KITTITAS COUNTY

MEMORANDUM

TO: All Staff
FROM: Public Works Plan Review Team
DATE: November 4, 2025- UPDATE 2/19/2026
SUBJECT: BL-25-00016 Andersen

**ANDERSEN BLA
SITE PLAN**

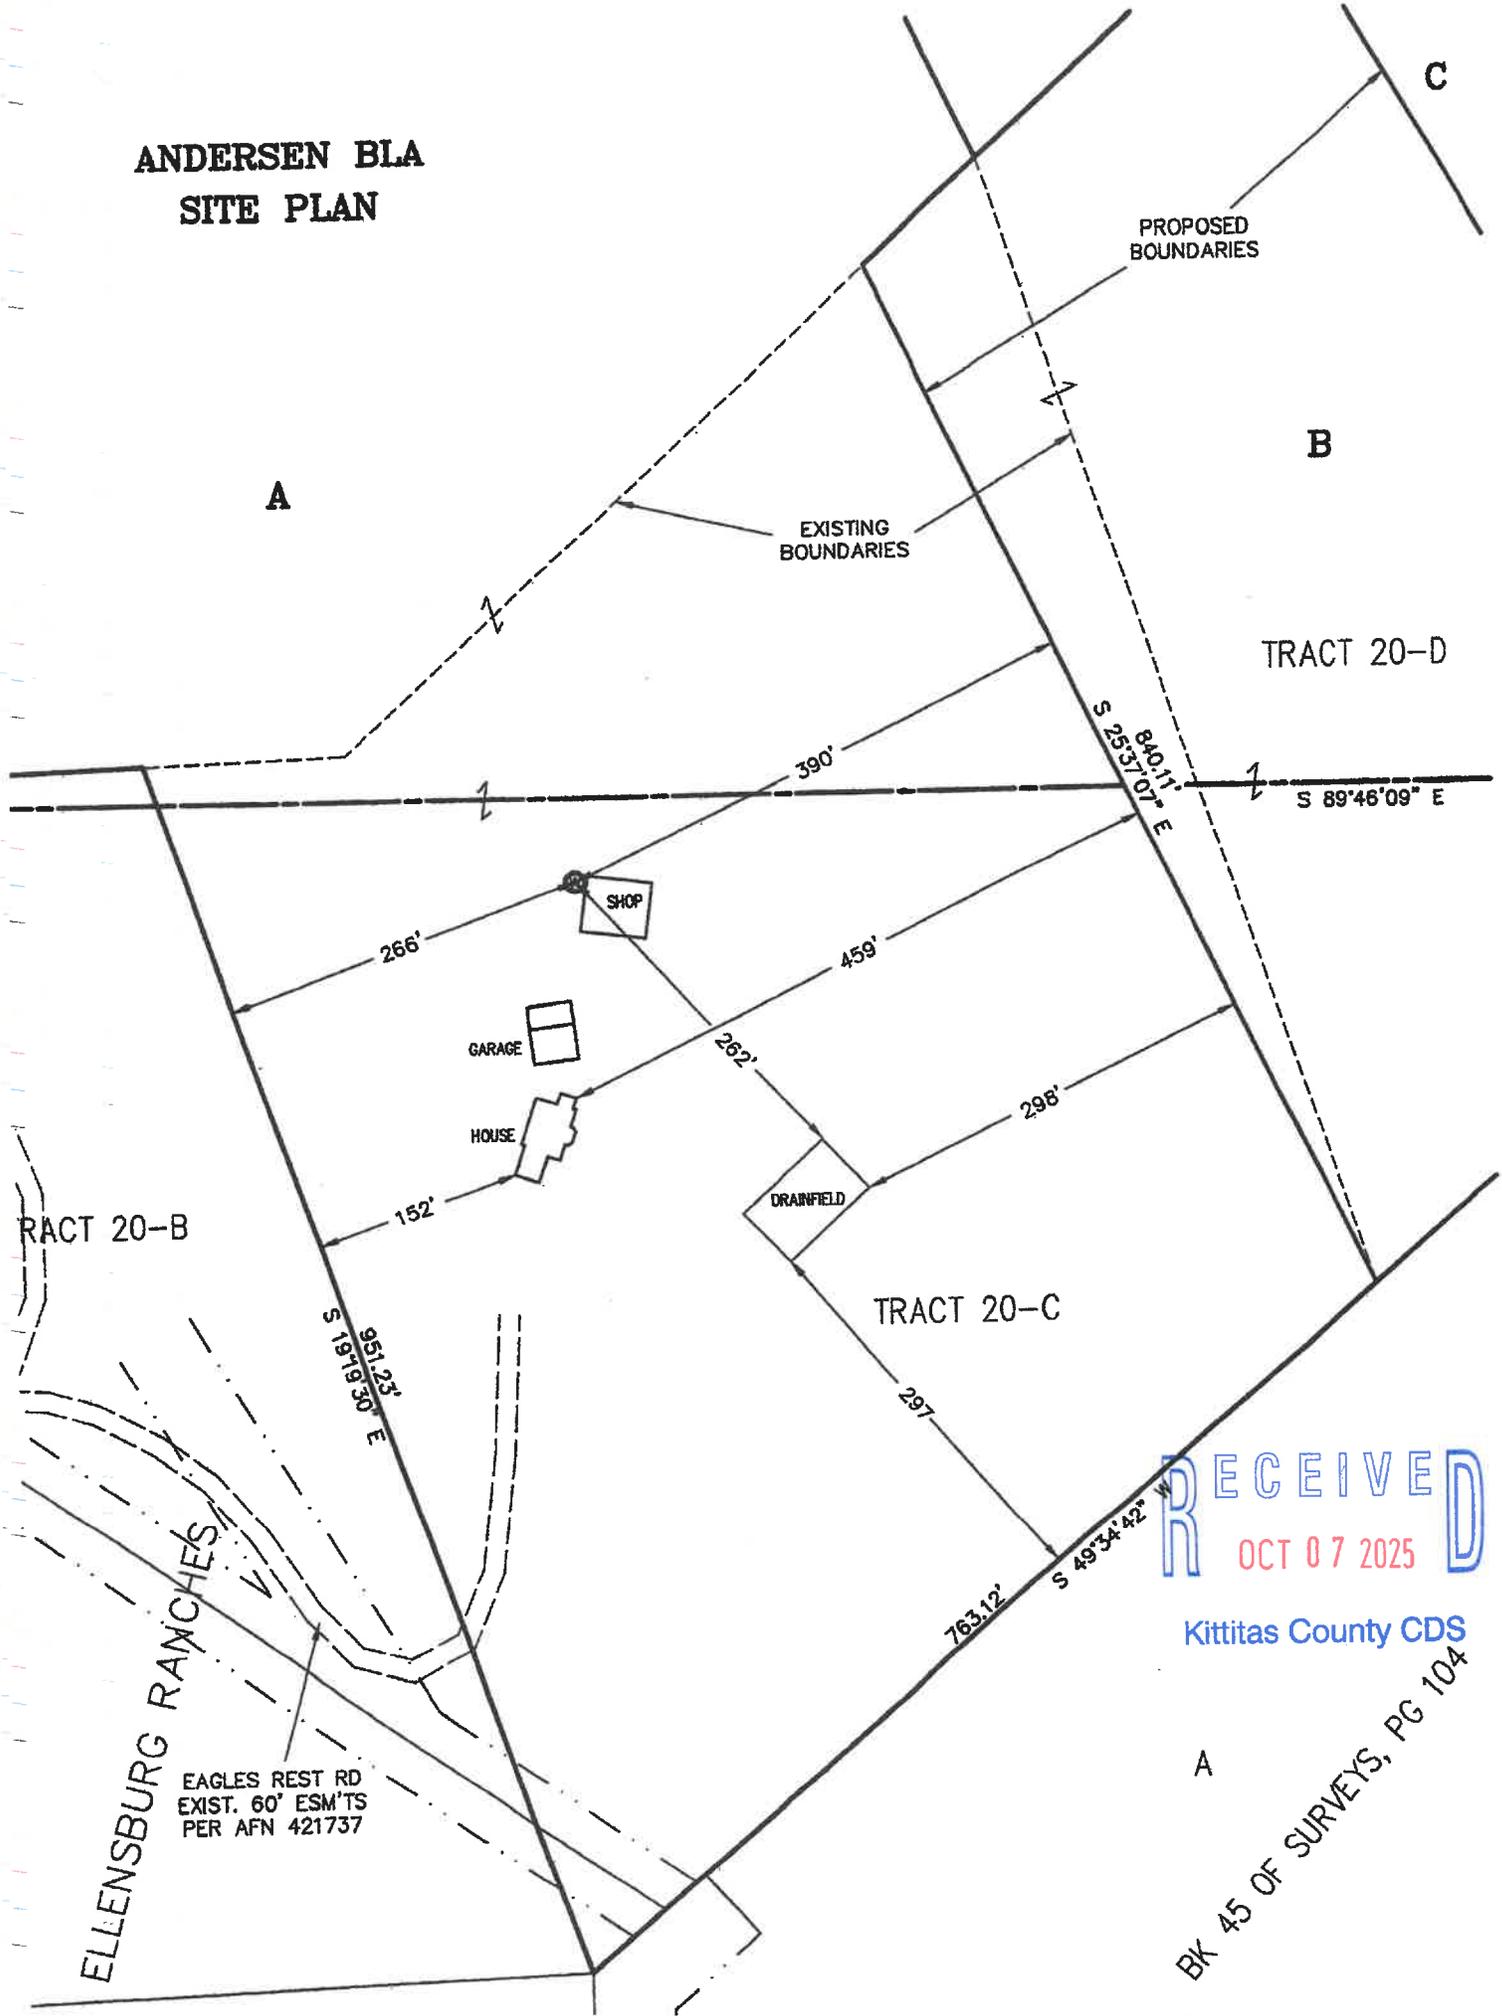
ENGINEERING	<p>Except as exempted in KCC 14.05.060, no grading or filling upon a site involving more than one hundred (100) cubic yards shall be performed without a grading permit from the County Engineer or Public Works designee (KCC 14.05.050). An application for grading in excess of five hundred (500) cubic yards shall be accompanied by an engineered grading plan (KCC 14.05.080). (CBP)</p>
SURVEY	<p>Waiting for final application/Record of Survey before making comments</p> <p>UPDATE 02/18/2026</p> <ol style="list-style-type: none"> 1. Please show and label Eagles Nest Road through Parcel A. Please label this as a private road and include the surfacing material. If you choose to include the easement limits, please show the easement width. 2. There is likely a structure on Parcel A, near the West boundary. Either show this, or notify the county that it is a trailer, concrete pad, or other non-structure.

**SHEET 1 OF 2**

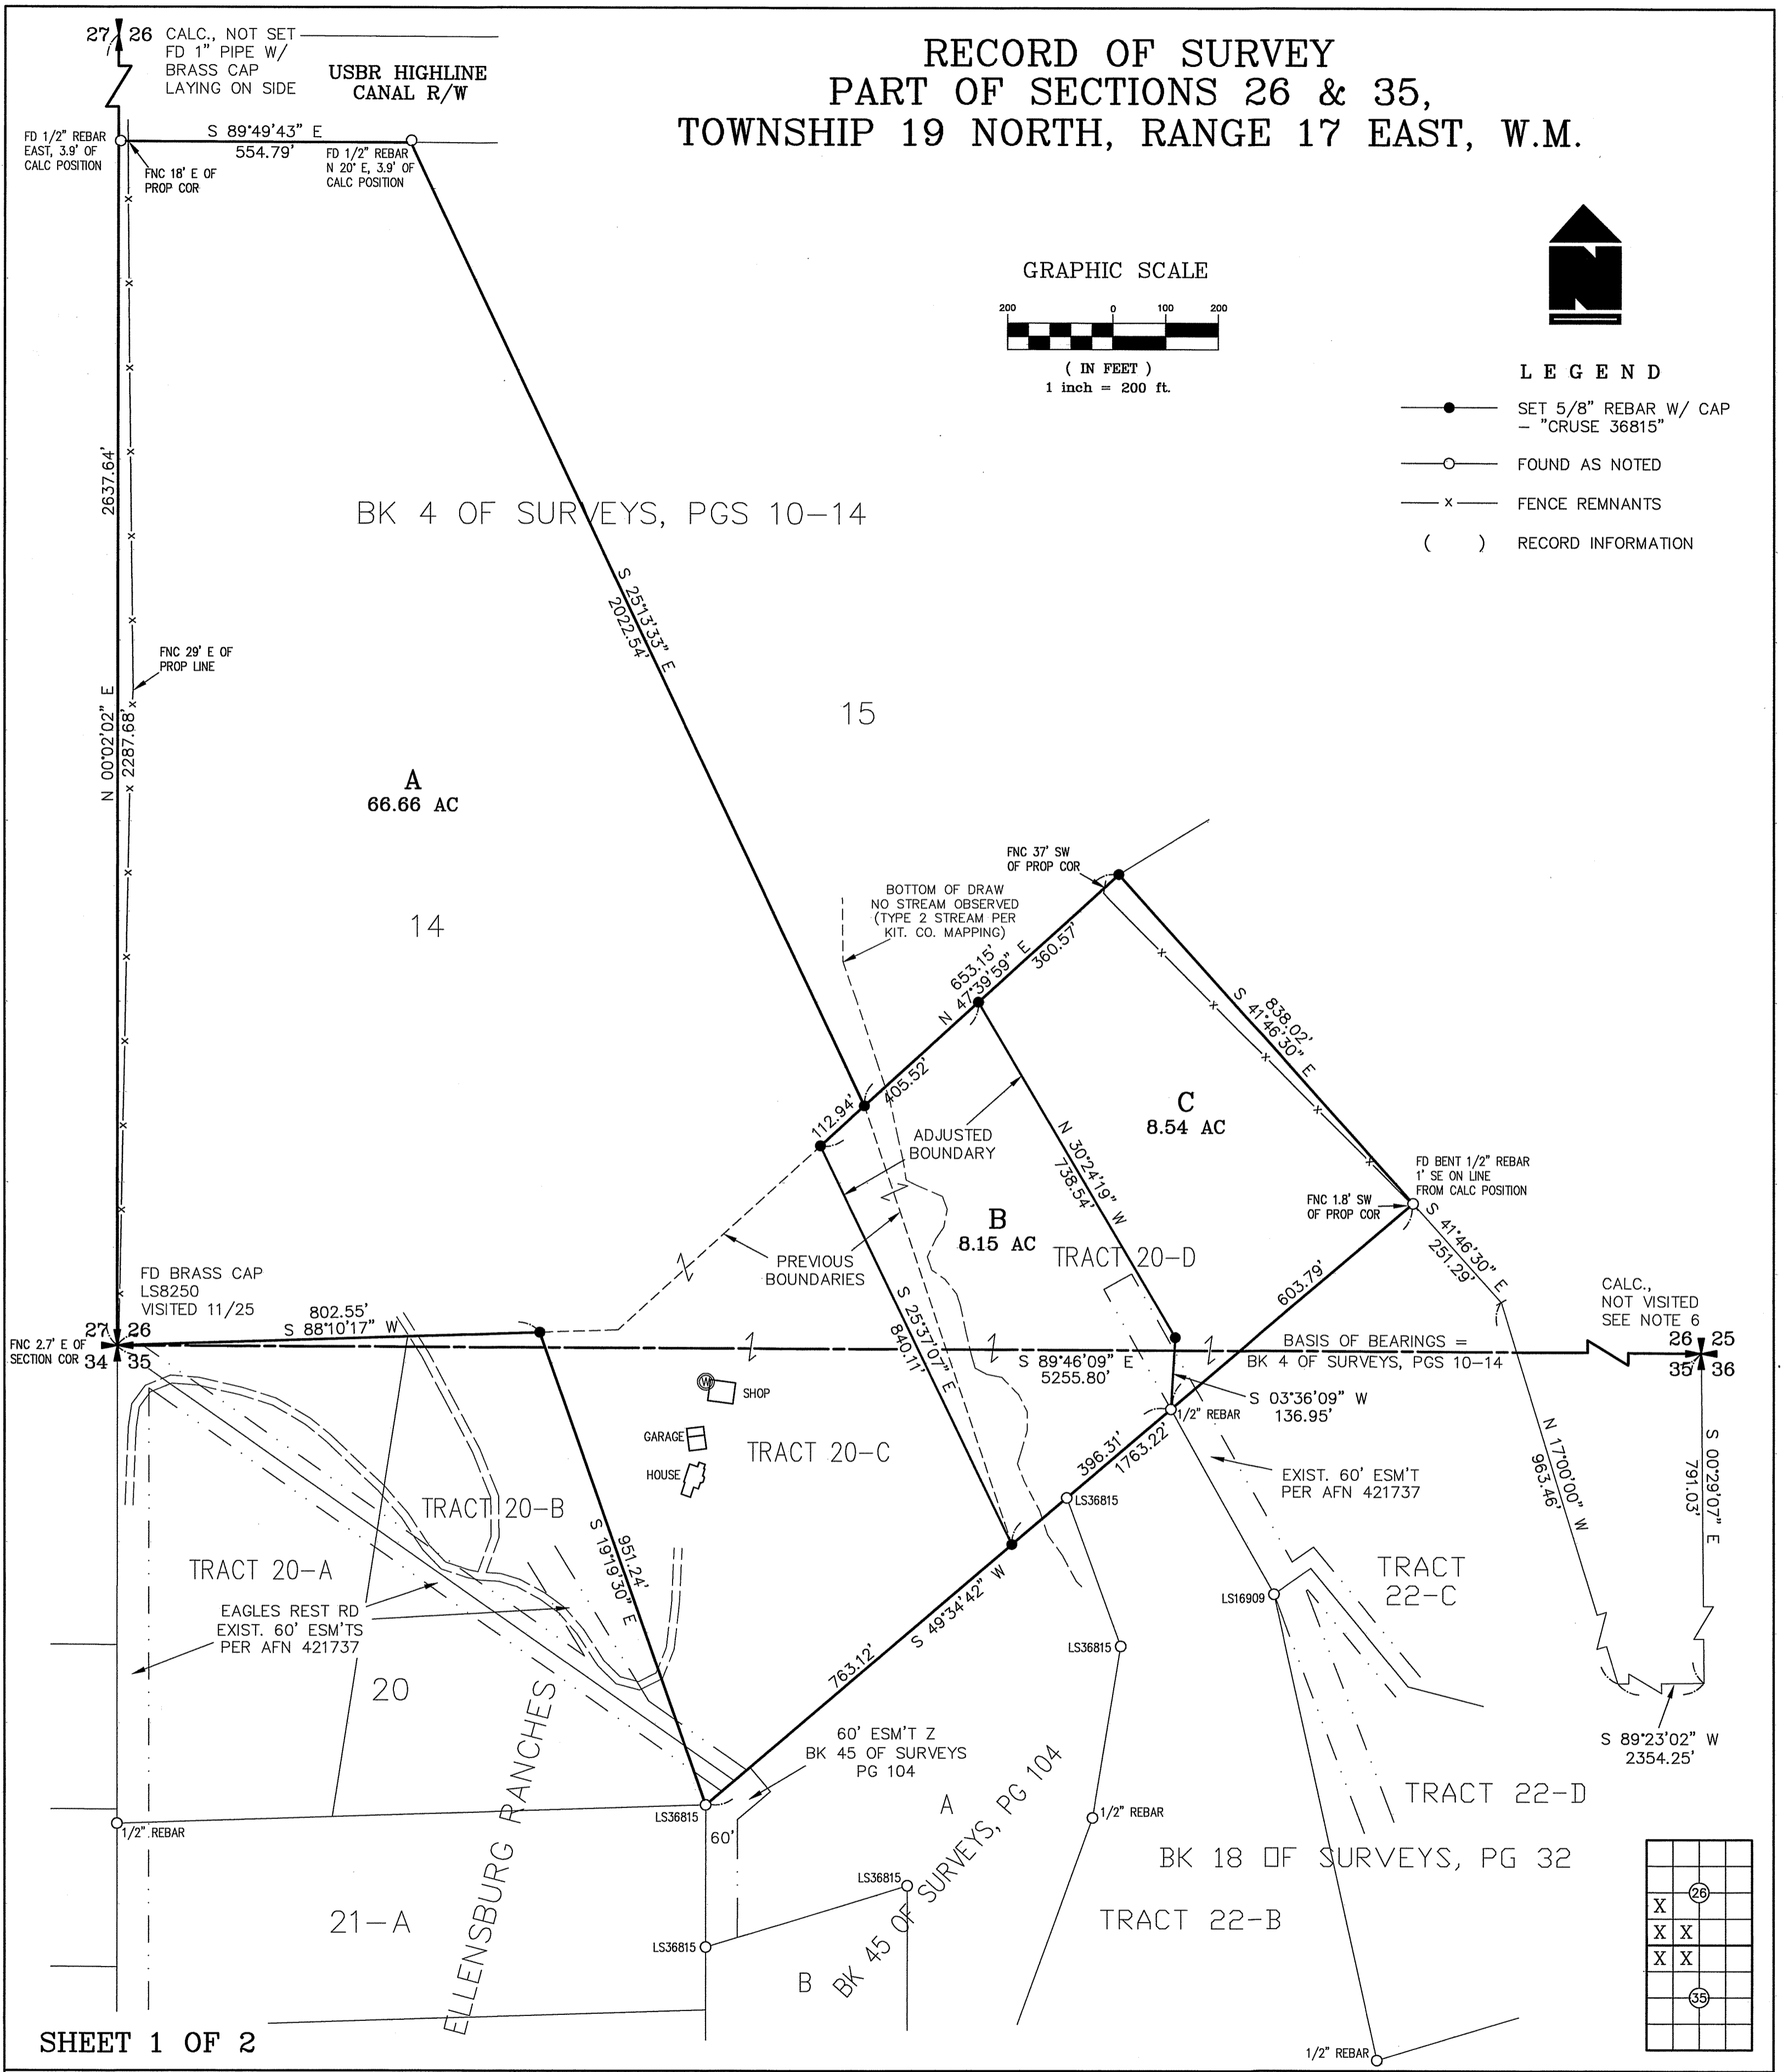
<p>3. Note 5 does not meet the intent of RCW:58.09.090(1)(d)(iv), or WAC 332-130. While this code is being interpreted from whether a Record of Survey is required, it stands to reason that the same level of accuracy would be met on a Record of Survey. Please change this tolerance to 0.50' and label corners accordingly. NOTE: An opinion from DNR's Survey Advisory Board deeming the existing note as suitable would be an acceptable alternative to changing Note 5. (JT)</p> <p>UPDATE 02/19/2026 The most recent map update has addressed all prior survey comments. (JT)</p>
TRANSPORTATION CONCURRENCY	No transportation concurrency management requirement for this project.(RC)
FLOOD	No comments. (SC)
WATER MITIGATION/ METERING	No comments. (SC)
AIRPORT	No Comments. (RC)
